**NSW P&E Ref: 8\_0167 Belle O'Connor St**

**08\_0167 MOD2, Modification to Residential Subdivision - 08\_0167 MOD 2**

**RE: Section 75W Modification of Consent – Stage 10 and 11 of MP 08\_0167  
Lot 36 DP 1214499 Belle O'Connor Street, South West Rocks.**

The purpose of this letter is to address matters raised in agency and public submissions to the proposed modification of consent.

| Drawing No.   | L36-MOD01 |

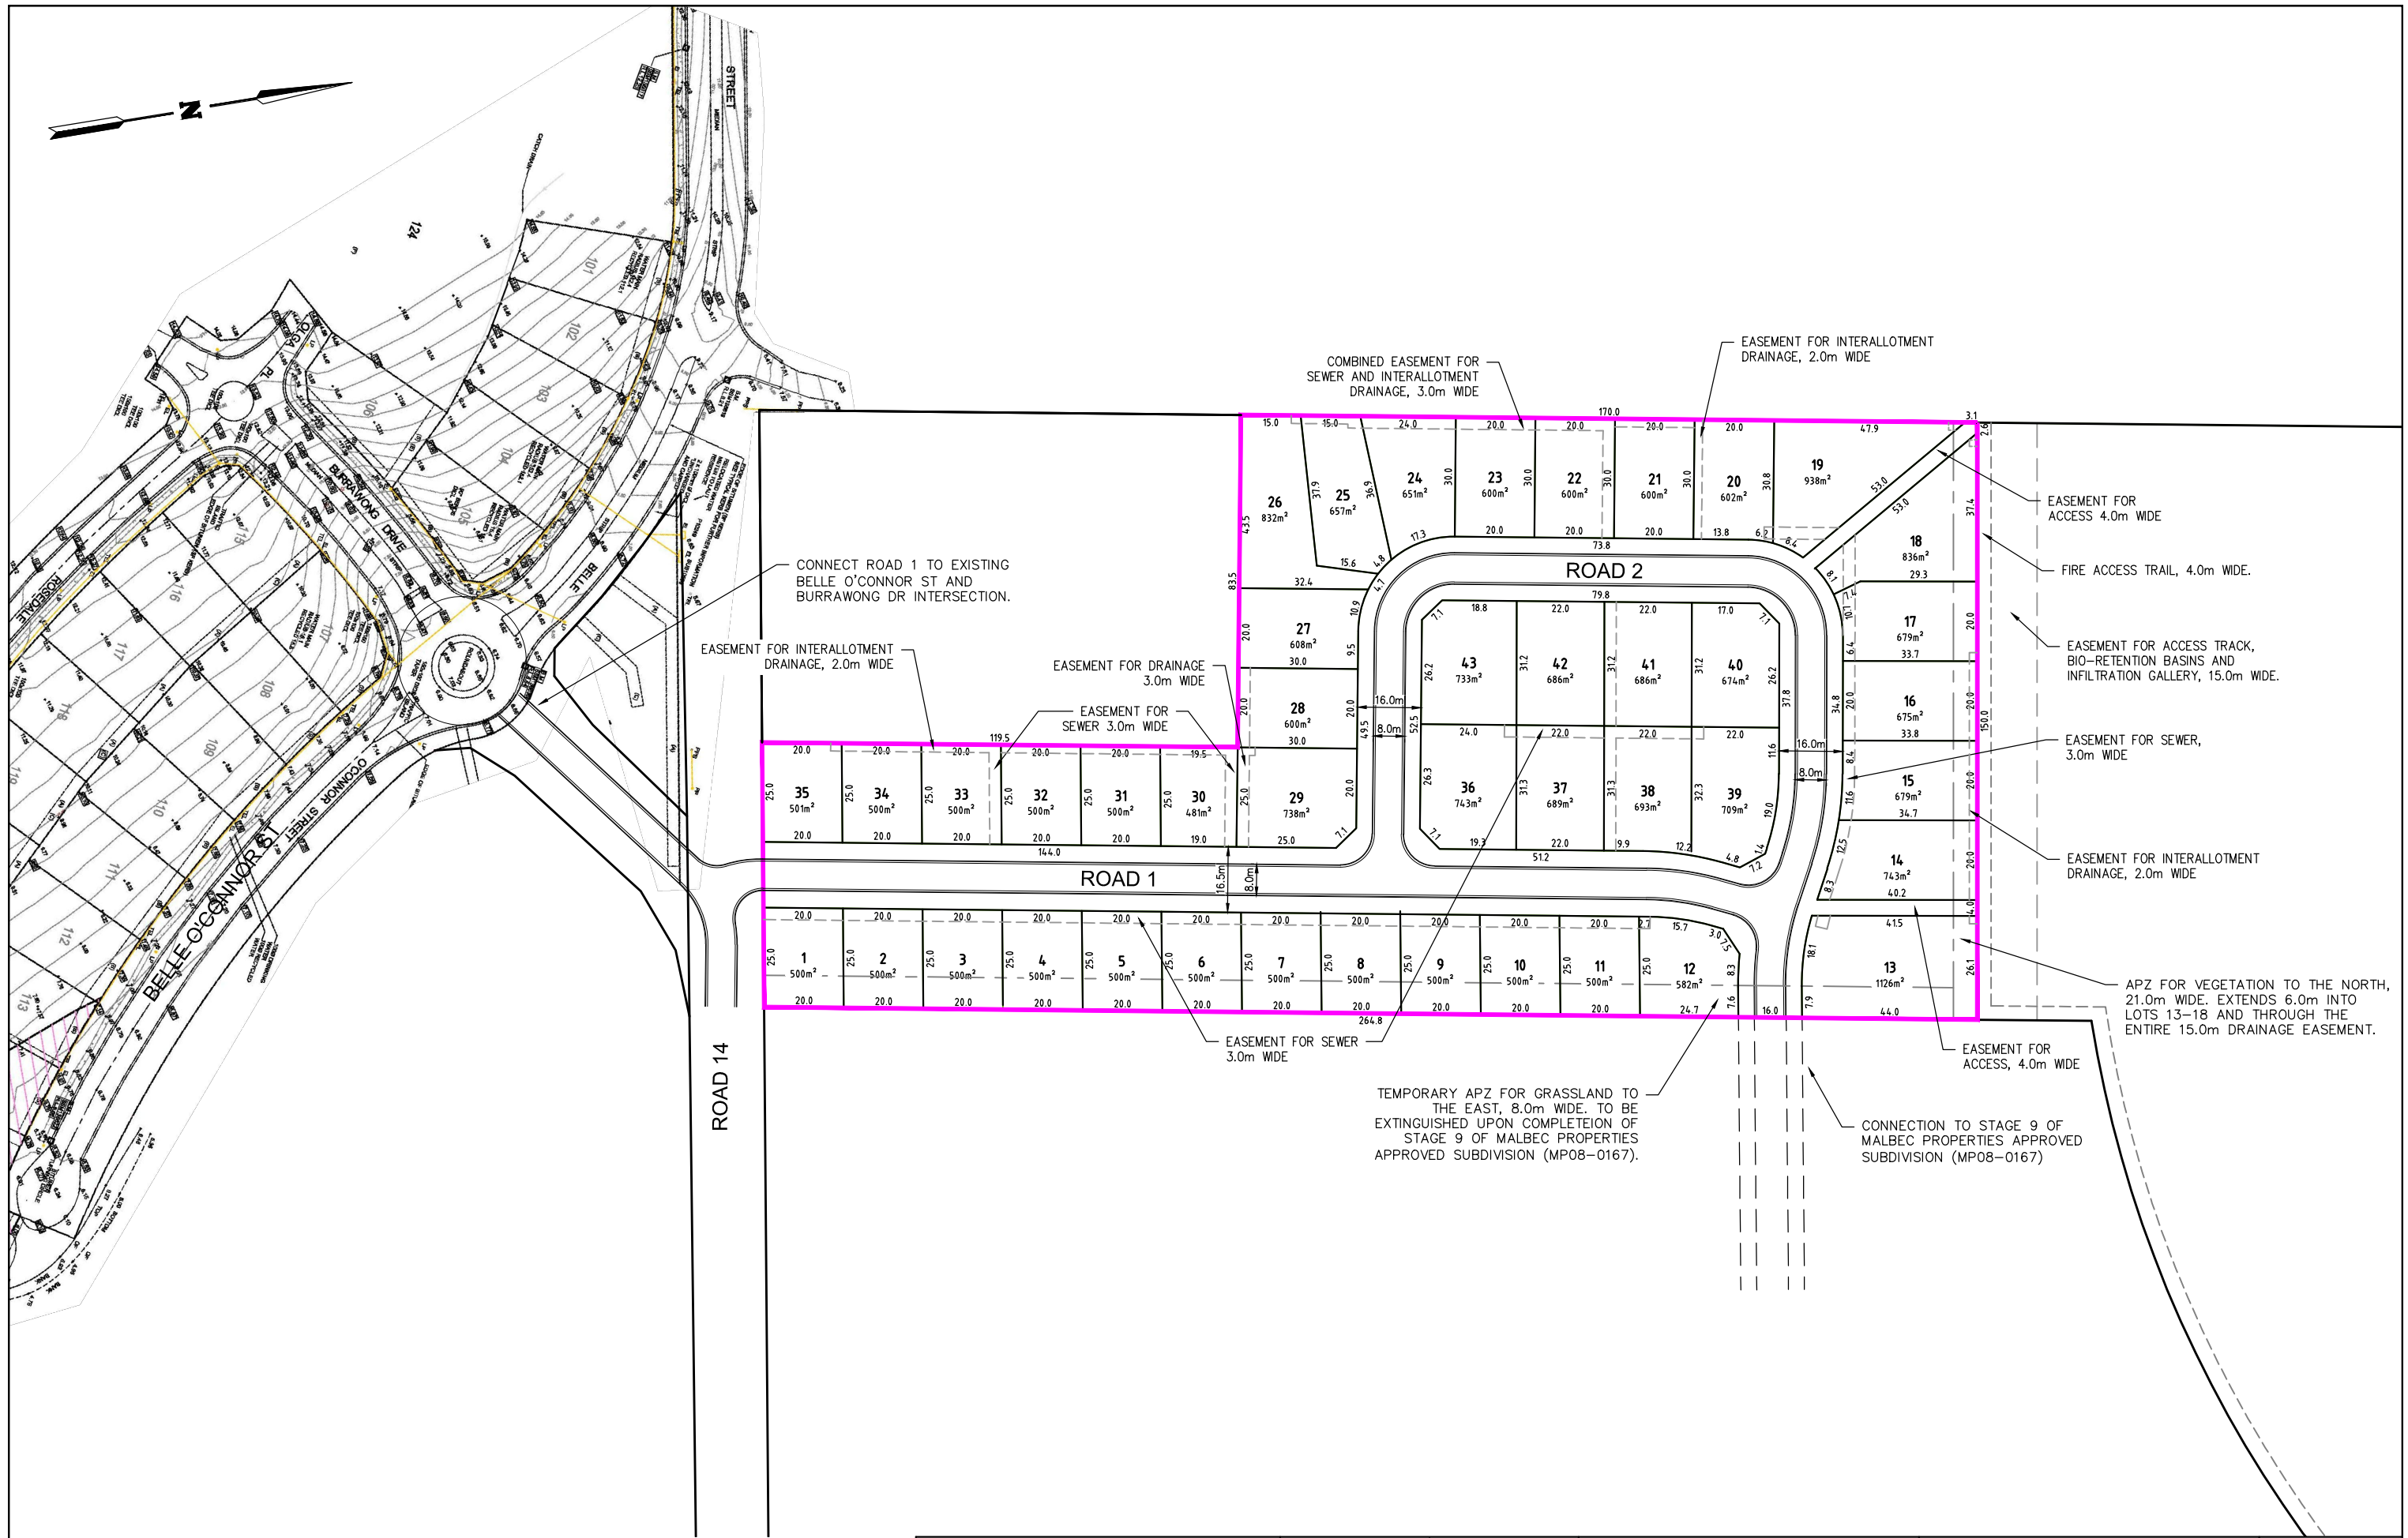
<b>The application should be amended to clearly show the location of the northern drainage easement with respect to access to the bushland interface. The extent of land that will be managed in this area should be detailed and the corresponding extent of APZ that will be required on Lots 13 to 19.</b>	Refer to DWG L36-MOD02 – DA1.
<b>The modification application has deleted APZs adjacent to Lot 51</b>	There is no requirement to provide an 8 m wide APZ along the boundary with Lot 51 DP 831284.

|        |   | Drawing No.   | L36-MOD03 |

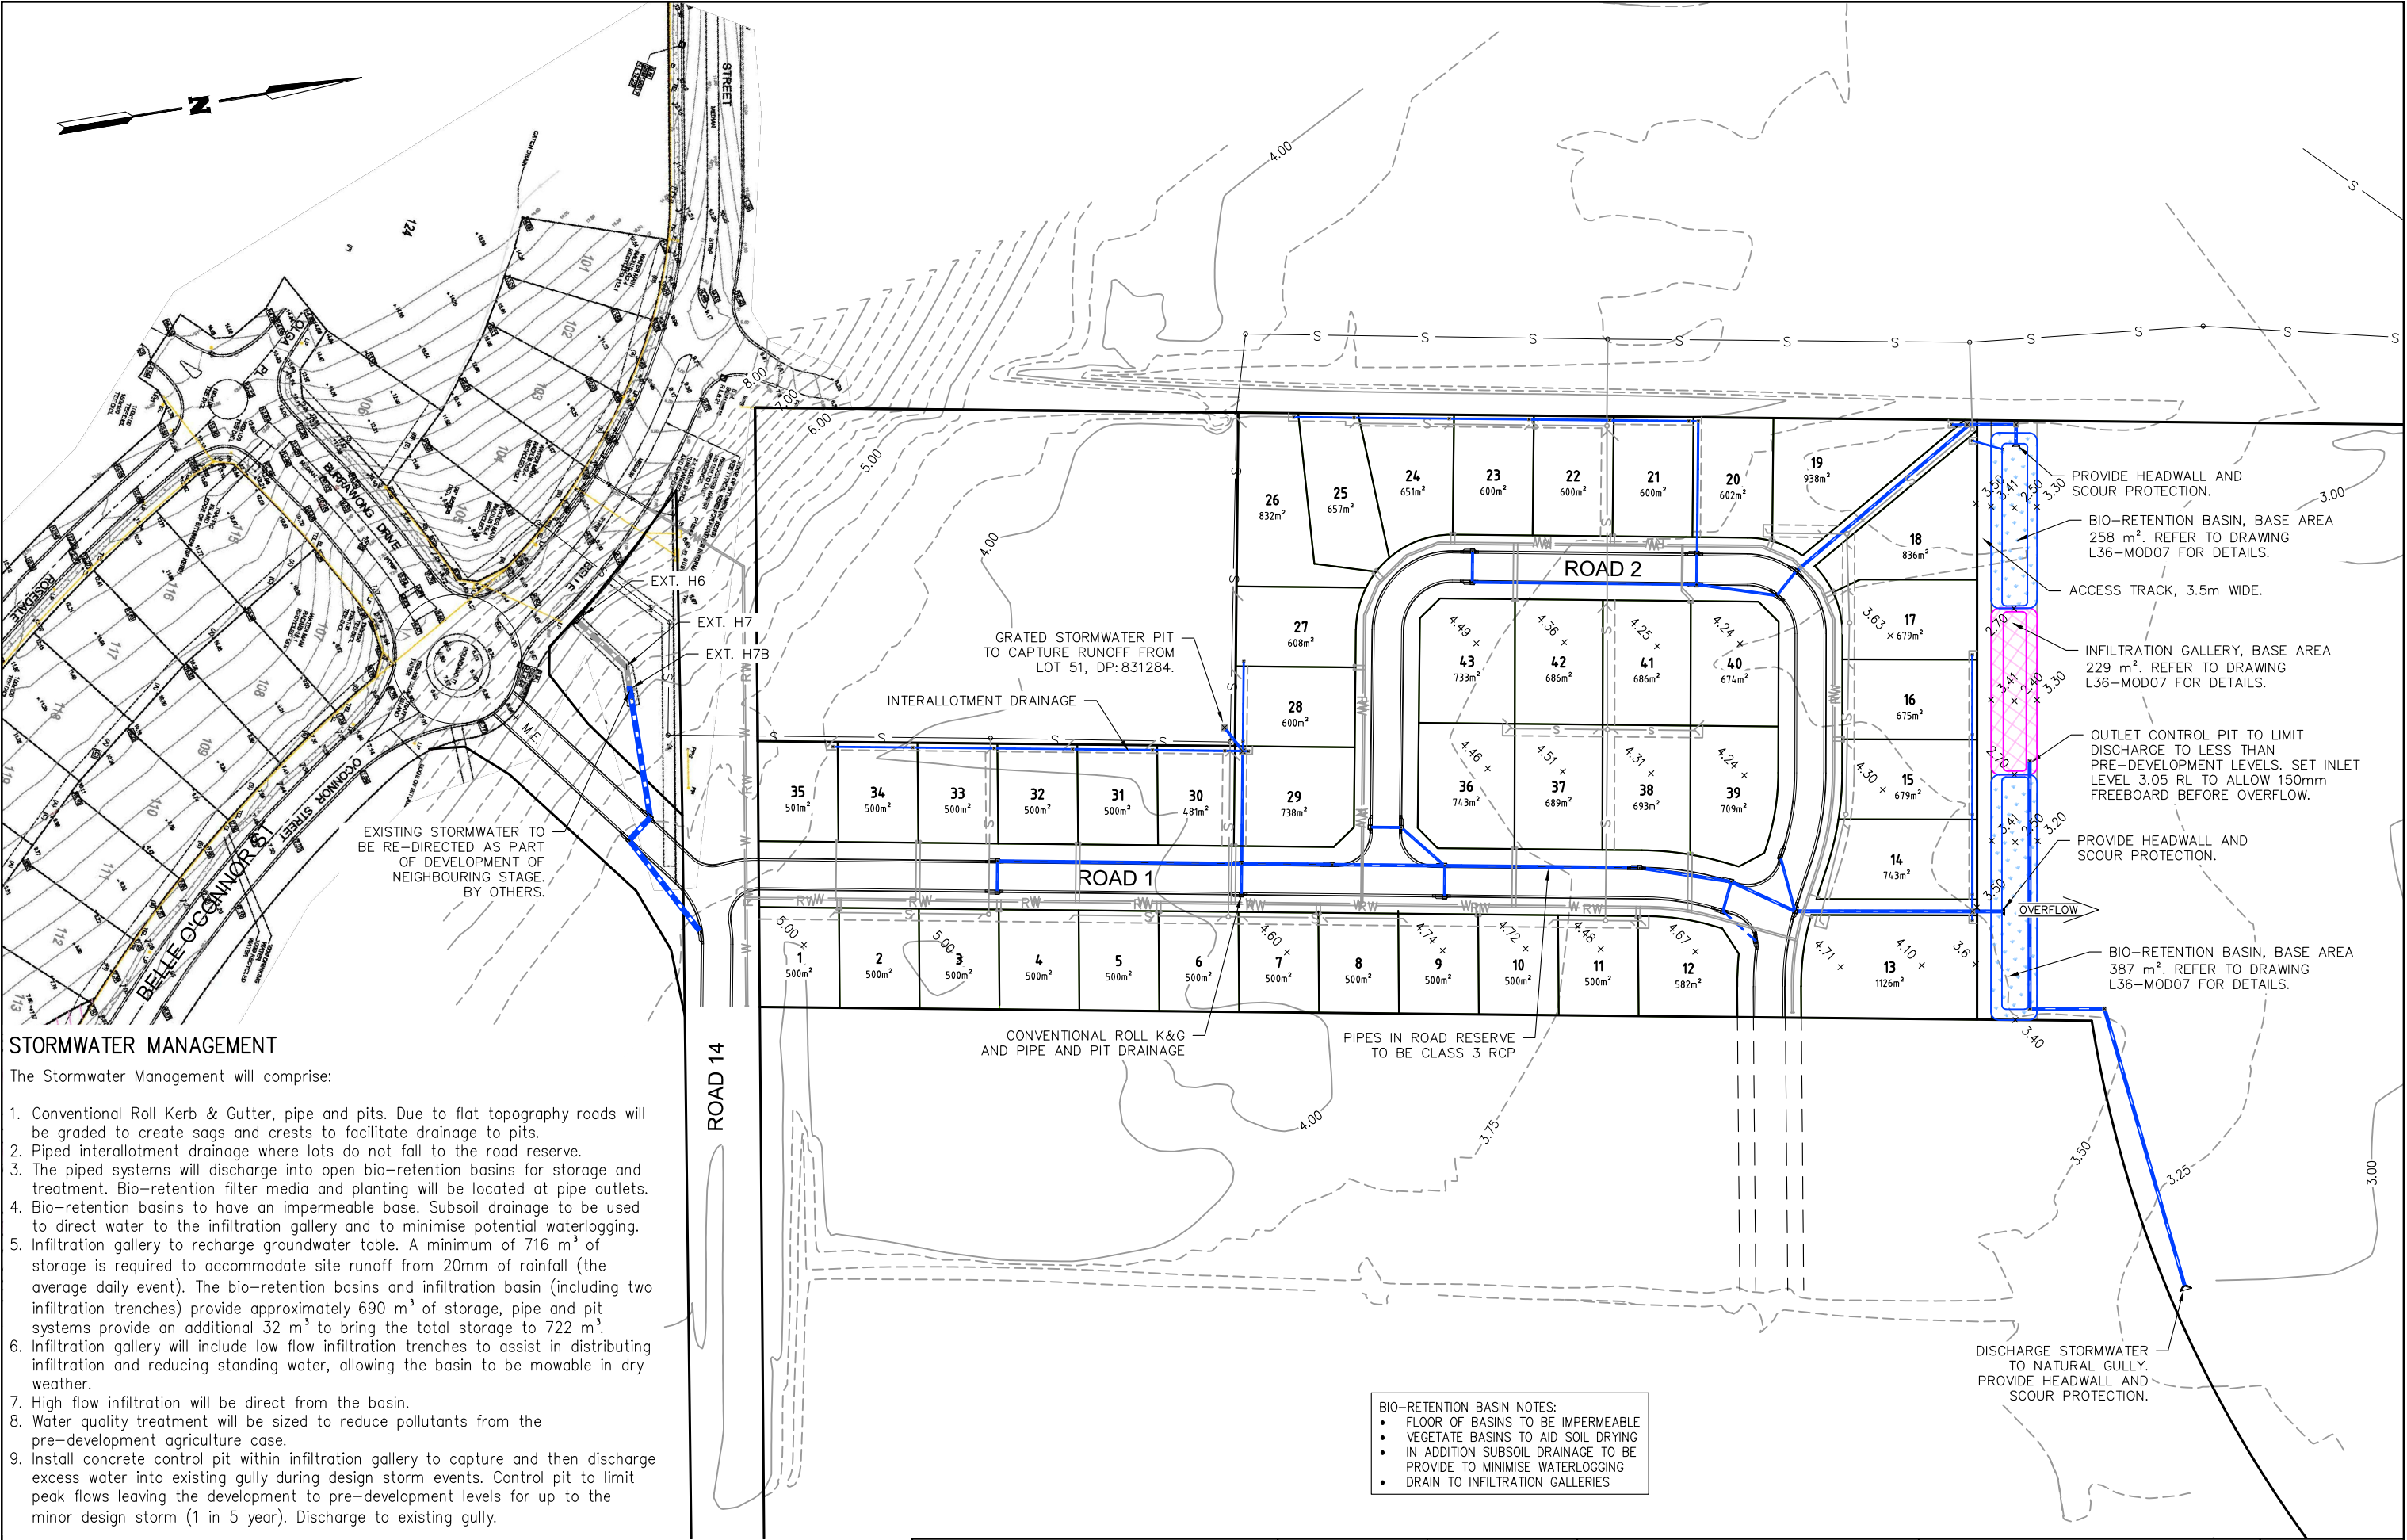
<b>Stormwater Management Stormwater quality, disposal and treatment are critical issues for this project, particularly given the relatively high water table and the sensitive SEPP 14 lagoon (and associated tributaries) within close</b>	As shown in the Concept Drainage Plan, stormwater management includes bio-retention within the existing 15 m wide drainage easement located at the northern boundary of the site within Lot 35 DP 1214499. The key stormwater management design principle is ensuring no adverse impact to the receiving

<p><b>proximity to the site. The Department should be satisfied that the stormwater management system is appropriate in the context of these constraints.</b></p>	<p>environment, consistent with the requirements of the project approval.</p> <p>Stormwater management for Lot 36 is specific to that development and does not rely on any stormwater treatment within the adjoining stages of the project approval.</p> <p>Lots 35 and 36 DP 1214499 are in the same ownership. The proponent for this Modification Application has the authority to deal with Lot 36 DP 1214499.</p>
<p><b>Open Space</b> <b>The modification (2) application does not provide detail as to how the open space requirements for Lot 36 will be achieved if it is to be developed independently of the remainder of the project.</b></p>	<p>Clause 6.13 of Chapter D2 of the Kempsey DCP makes the following reference:</p> <p><i>One guideline for open space provision is <b>1.3 ha per 1000 head of population</b>. The final lot yield, population and amount of open space required for the Saltwater precinct will be dependent upon the outcome of the recommendations of the traffic and water cycle management systems assessments. (Source: ERM South West Rocks Open Space Strategy 2004)</i></p> <p>Stages 10 and 11 of the project approval occupies a lot area of 3.577 ha and will provide residential housing for approximately 90 people (43 lots x 2.1 people per household).</p> <p>On its own, Stages 10 and 11 generates the need for 1,170 m<sup>2</sup> of open space. Stages 10 and 11 has direct access to all of the environmental conservation zoned land held within Lot 35 DP 1214499. Within that land, the area shown edged blue in the image below has an area of 3.7 ha and is part of the site for which the project approval was granted.</p> <p>The area is considered to be the open space allocated to Stages 10 and 11 and is well in excess of the DCP requirements.</p>
